CITY OF ALBUQUERQUE

Re: Coors Plaza SW repairs
3200 Coors Blvd NW
Traffic Circulation Layout
Engineer's/Architect's Stamp 08/14/2019 (G11D006)

Based upon the information provided in your submittal received 08-15-2019, the above referenced plan cannot be approved for Building Permit until the following comments are addressed:

Sheet No.
C-001

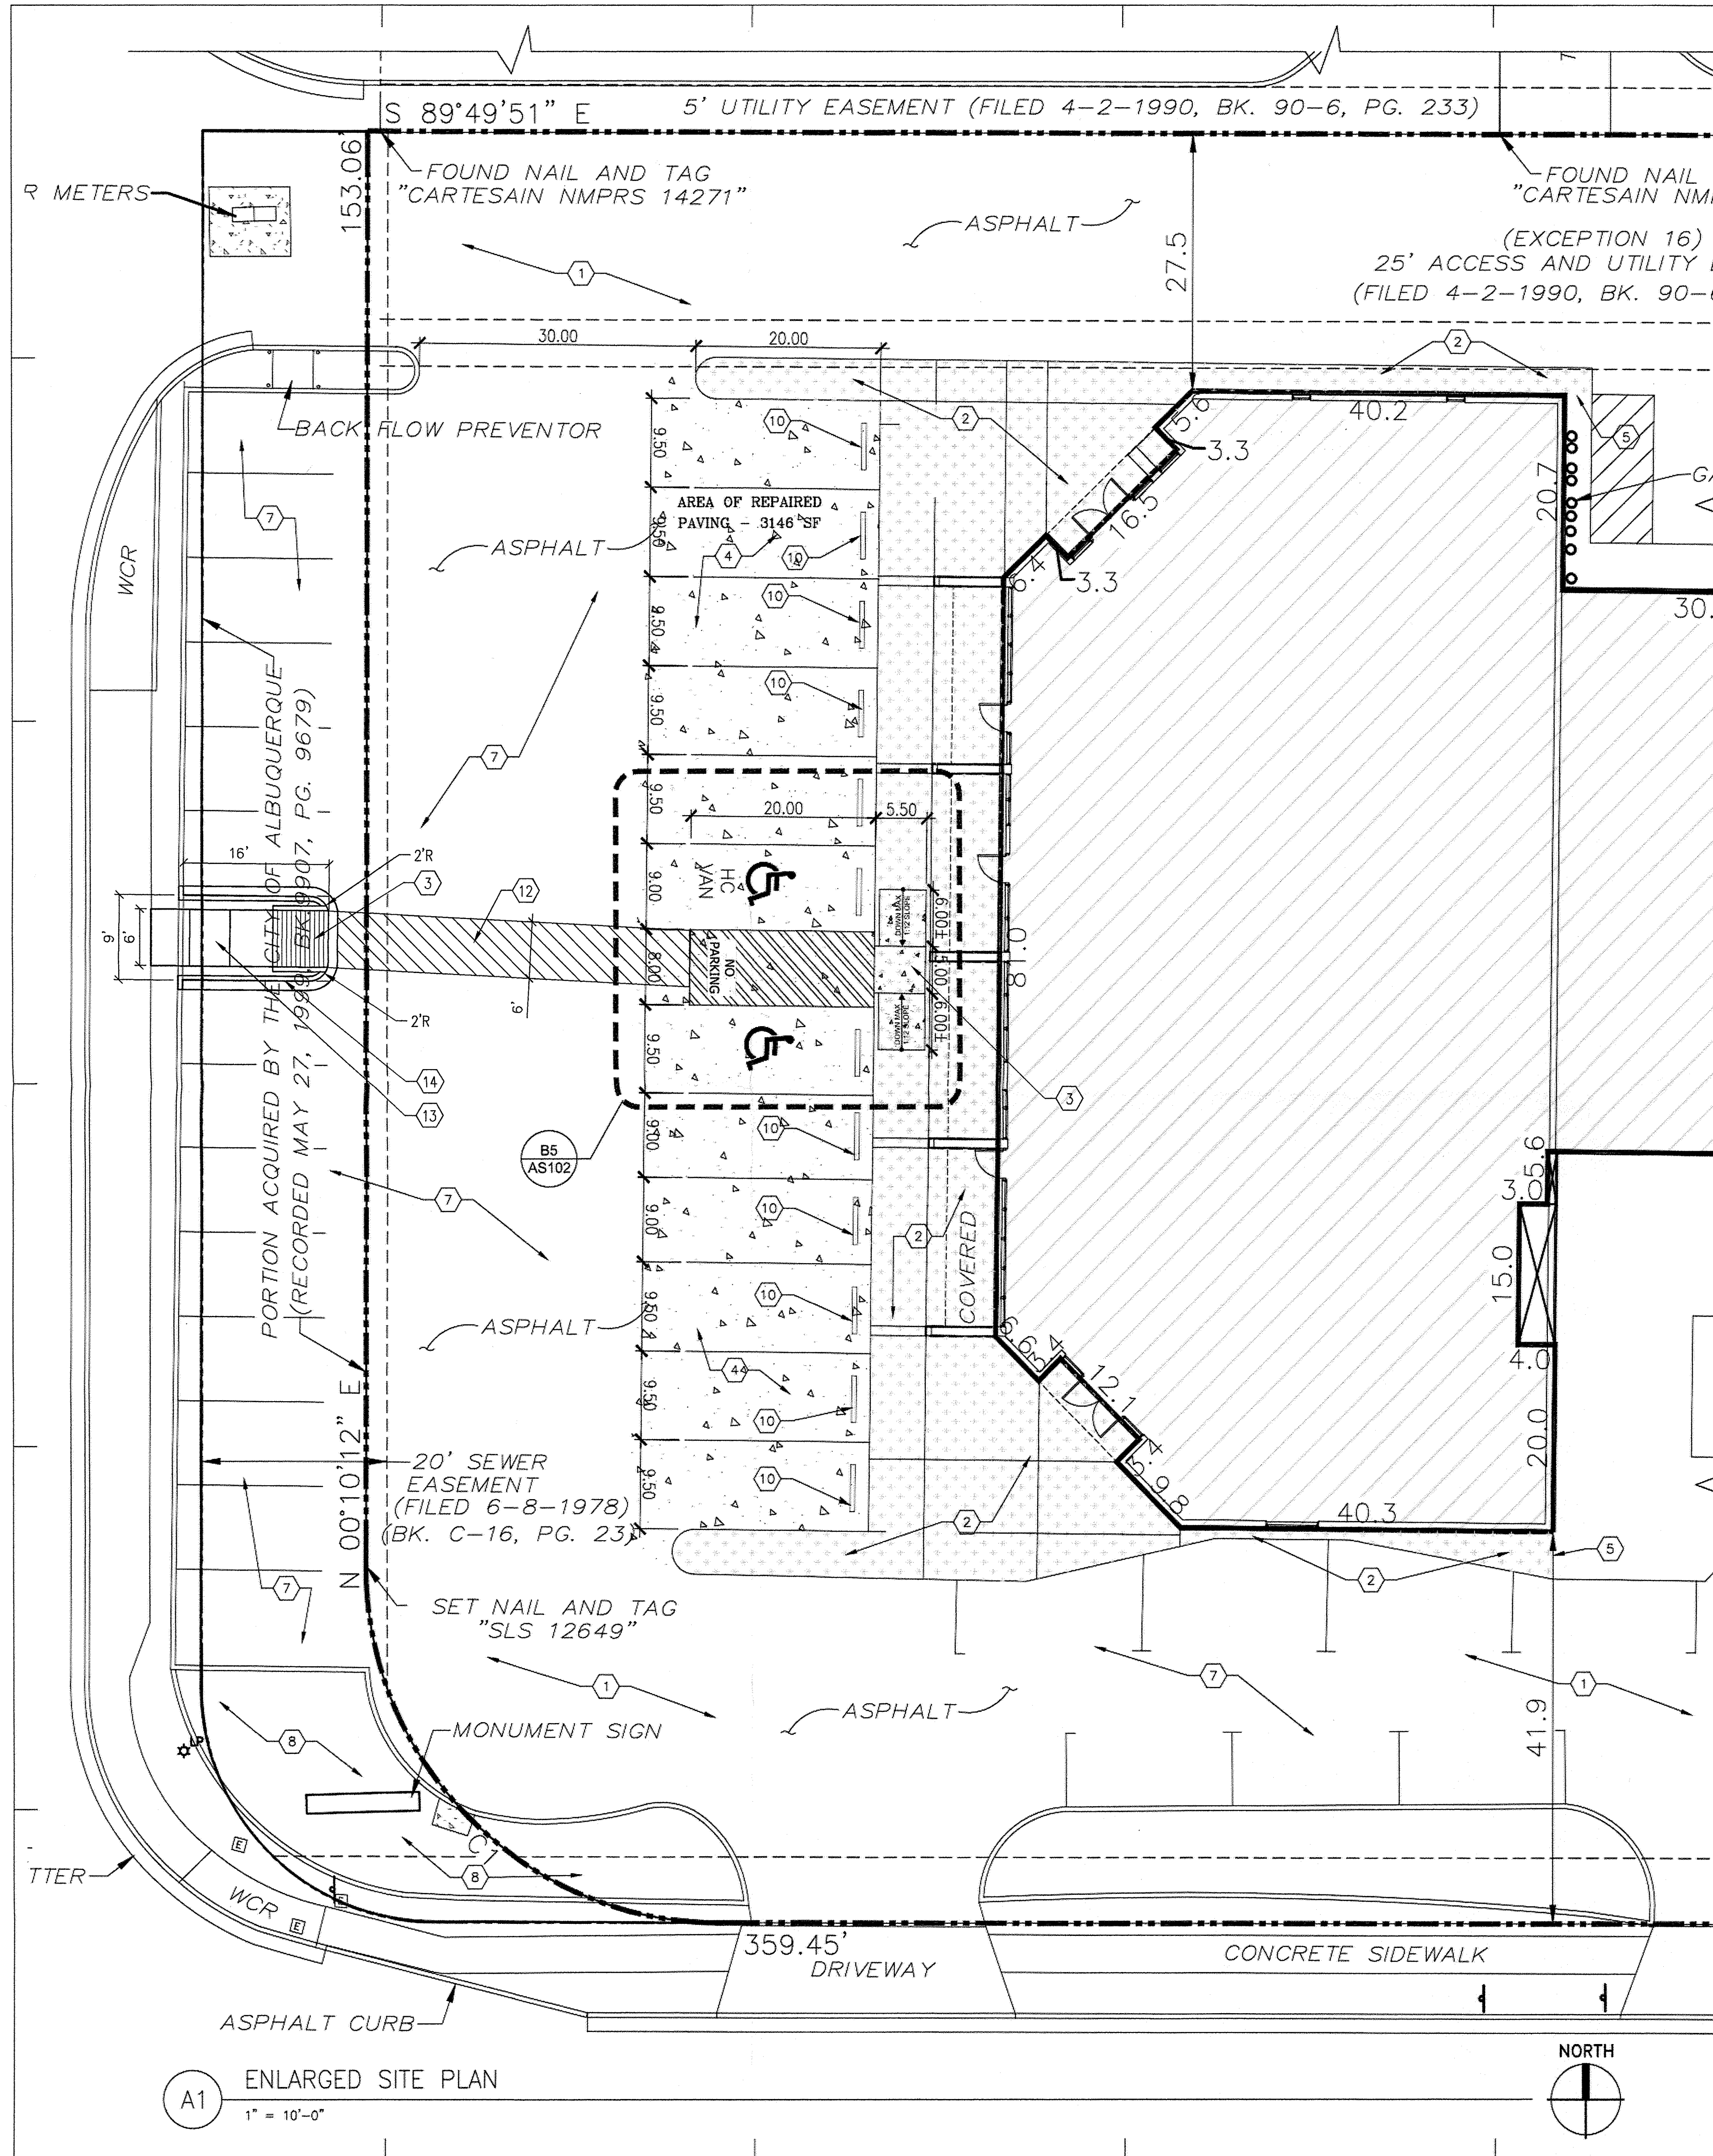
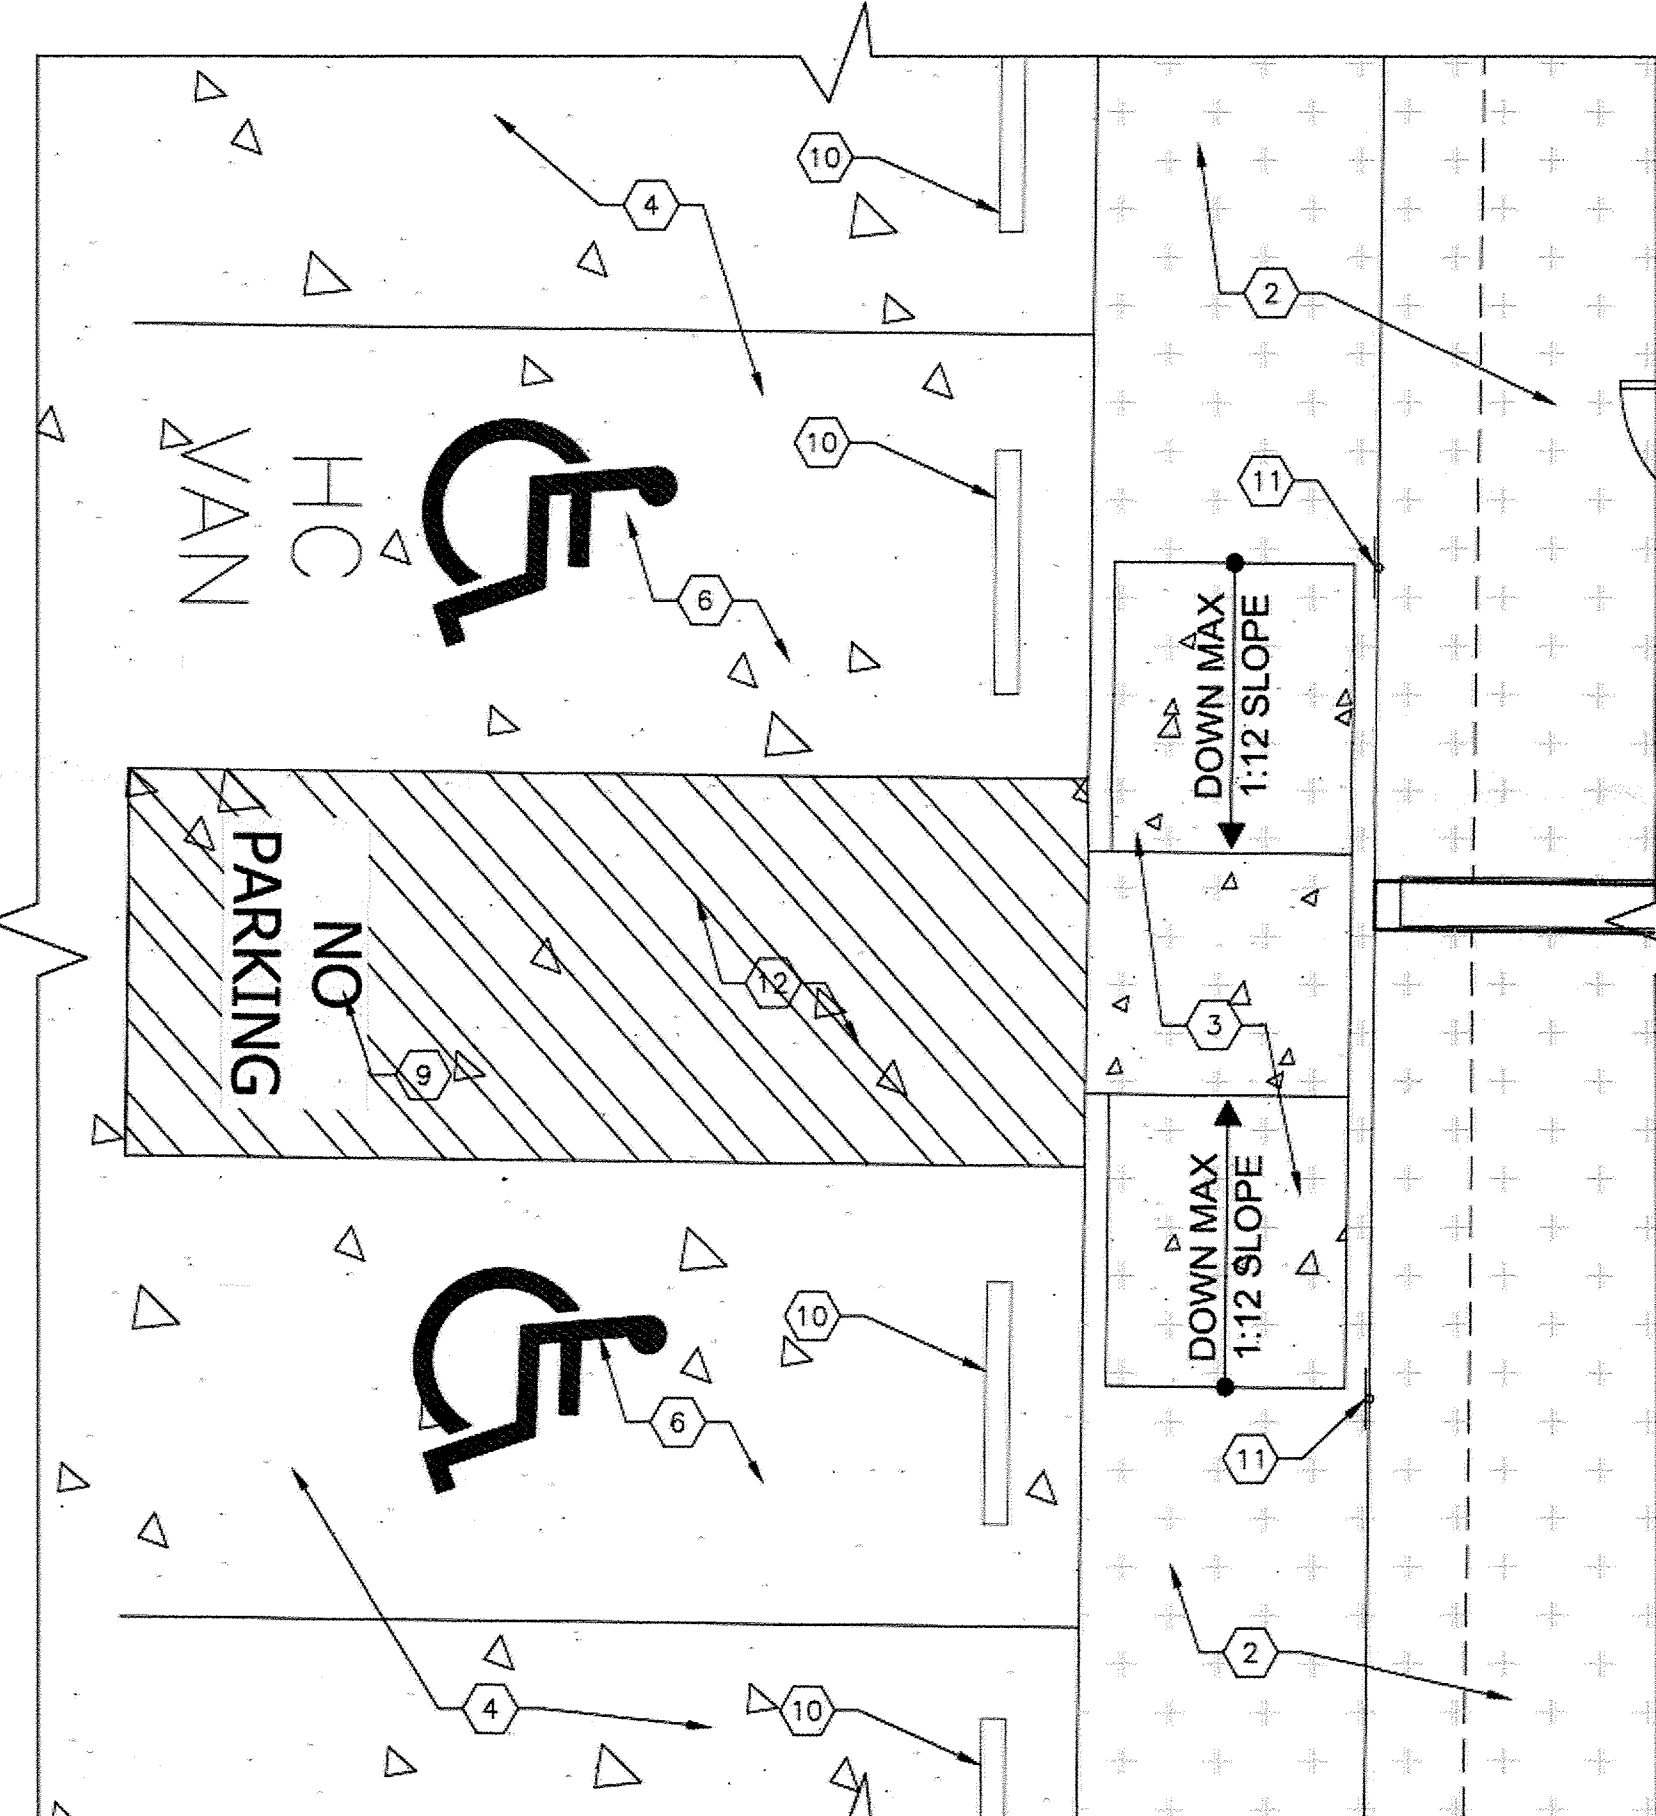
1. Please show a vicinity map showing the location of the development in relation to streets and well known landmarks.
2. List the number of parking spaces required by the zoning code as well as the proposed number of parking spaces including **bicycle and motorcycle parking**.

3. The ADA accessible parking sign must have the required language per 66-7-352.4C NMSA 1978 **"Violators Are Subject to a Fine and/or Towing."** Please call out detail and location of signs.

4. Motorcycle parking spaces shall be designated by its own conspicuously posted upright sign, either free-standing or wall mounted per the zoning code.

5. All bicycle racks shall be designed according to the following guidelines:
 - a. The rack shall be a minimum 30 inches tall and 18 inches wide.
 - b. The bicycle frame shall be supported horizontally at two or more places. Comb/toaster racks are not allowed.

- c. The rack shall be designed to support the bicycle in an upright position. See the IDO for additional information.
 - d. The rack allows varying bicycle frame sizes and styles to be attached.

- e. The user is not required to lift the bicycle onto the bicycle rack.
 - f. Each bicycle parking space is accessible without moving another bicycle.

6. Bicycle racks shall be sturdy and anchored to a concrete pad.
7. A 1-foot clear zone around the bicycle parking stall shall be provided.
8. Bicycle parking spaces shall be at least 6 feet long and 2 feet wide.

9. Refuse vehicle maneuvering shall be contained on-site. The refuse vehicle shall not back into the public right of way.; provide a copy of refuse approval.
